Environmental Health Division
1675 W. Garden of the Gods Road
Suite 2044
Colorado Springs, CO 80907
(719) 578-3199 *phone*
(719) 578-3188 *fax*
www.elpasocountyhealth.org

Boy Scout Recreation Camp, PPR-20-11

Mike McCarthy
El Paso County Public Health
Environmental Health Division
719-575-8602
mikemccarthy@elpasoco.com
22May2020

EL PASO COUNTY DEPARTMENT OF HEALTH AND ENVIRONMENT
INDIVIDUAL SEWAGE DISPOSAL SYSTEM INSPECTION FORM

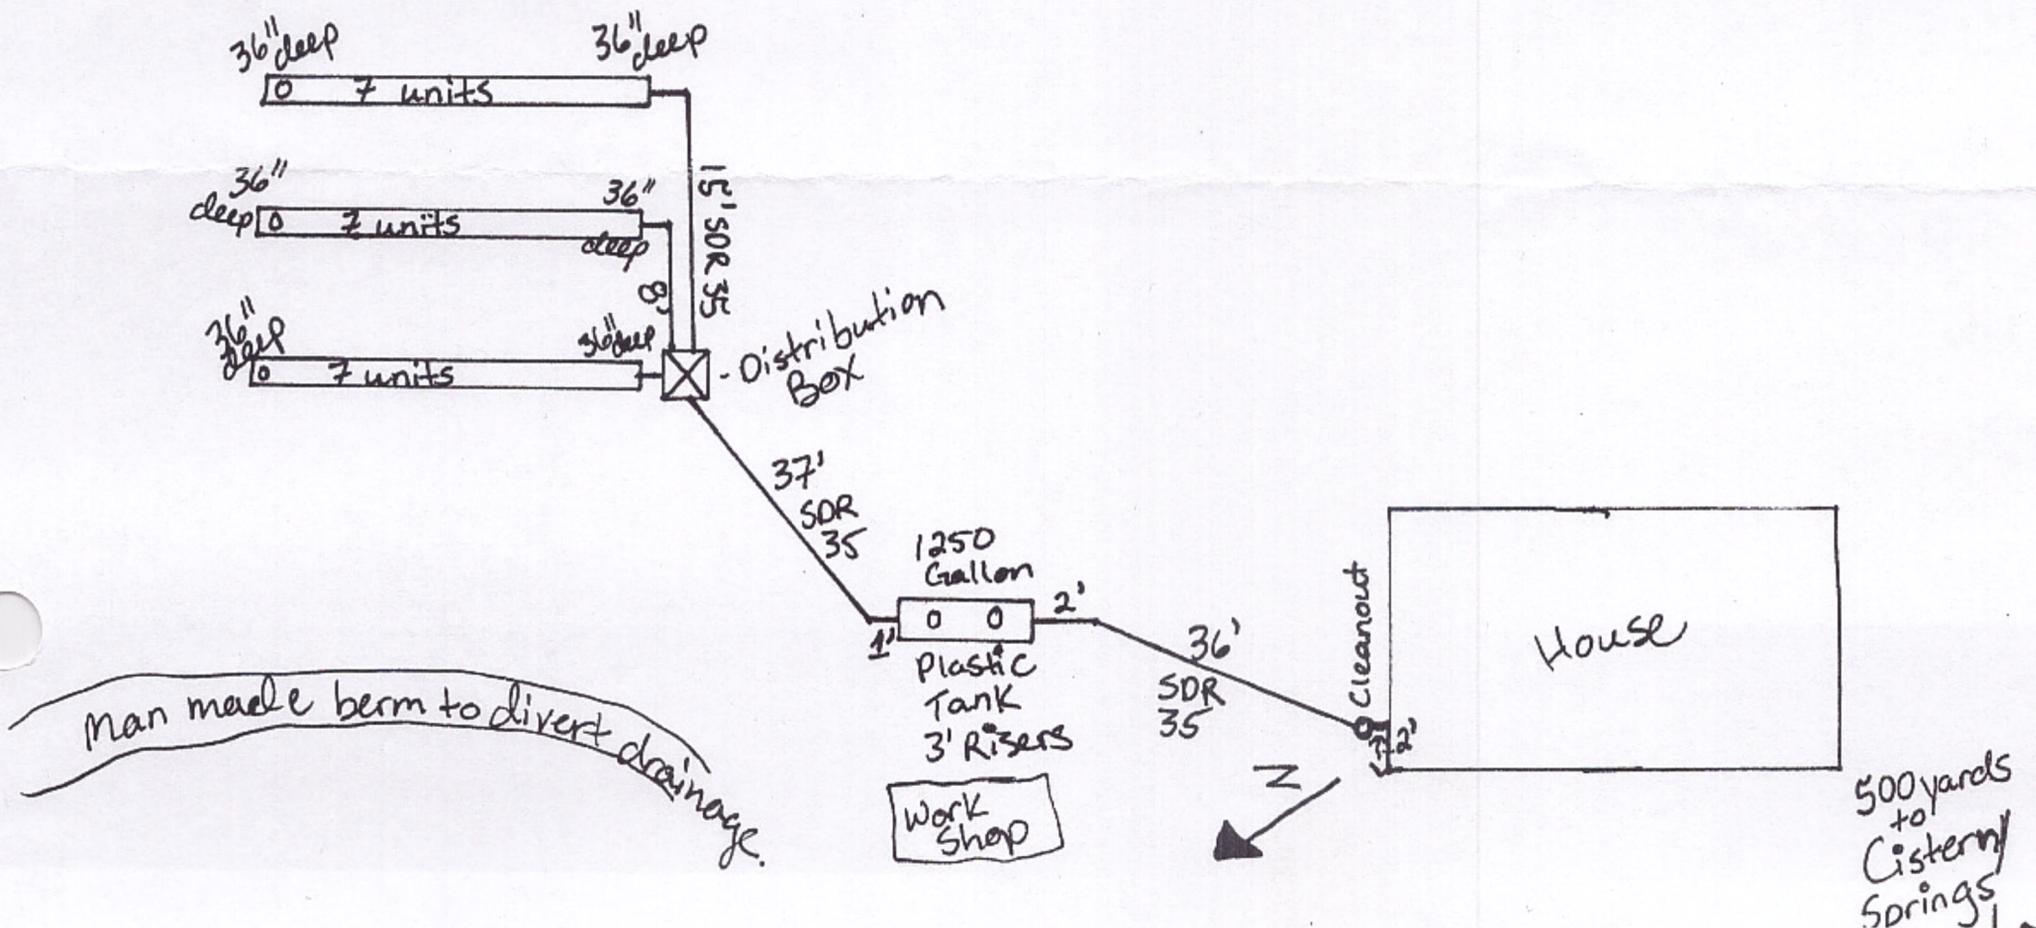
- **There is a record of an approved, permitted on-site wastewater treatment system (OWTS) for this property indicates the OWTS was installed and approved in 2010. The OWTS component locations are available on the El Paso County Assessor's Office website and on file at El Paso County Public Health under Tax Schedule Number (TSN) 820000064.**

- **El Paso County Public Health recommends all components of the OWTS are located and protected from vehicular traffic, livestock and other means of compaction to help prolong the life of the system. A secondary site on the property must be preserved for the possibility of a repair, addition, or replacement of the existing soil treatment area. Fencing is preferred but other area identification methods accomplishing the same goal are approved.**
